Application No: A/24/21/PL
Site Address: Land South of Water Lane Angmering
Description of works: Erection of a temporary sales cabin with 4 parking spaces and associated landscaping. CIL Zone 1 - This application is zero rated as temporary building.

Thank you for your internet representation made on 16th March 2021 which has been recorded as an objection with the comments as follows:

I am writing to register my objections to the proposed planning application A/24/21/PL. My Grade II property is directly opposite the proposed entrance to the sales cabin.

DWH SUPPORT RED
C31 M87 Y66 K25

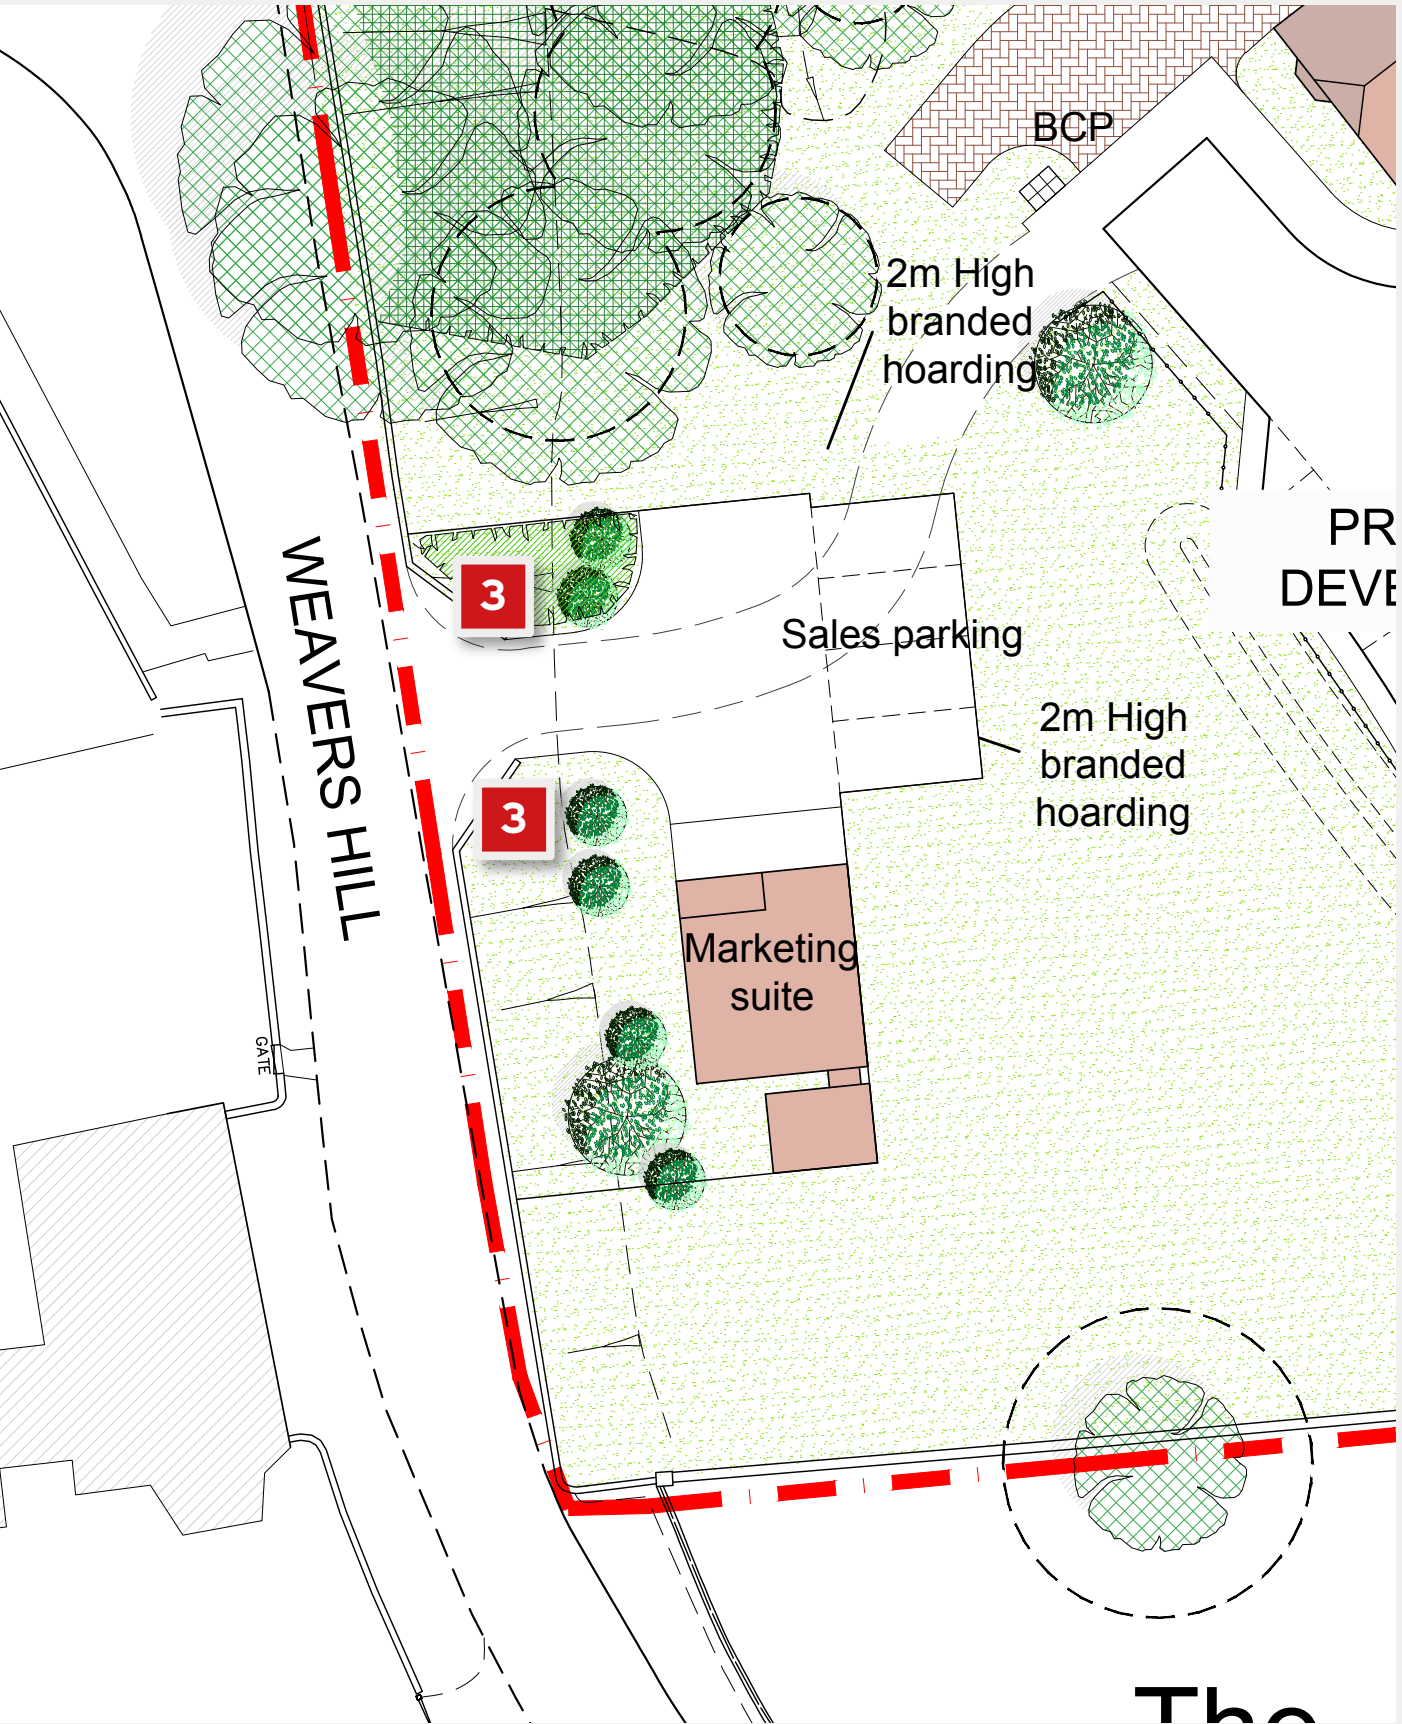
The erection of 10 advertising totem signs and 5 advertising flags, prominent commercial structures designed

to attract attention from a distance, will be totally out of place and will have a detrimental effect for multiple years on the character of the Angmering Conservation Area. The flags and the associated rope will generate noise in the wind and cause disturbance to the residential properties close to the site for multiple years.
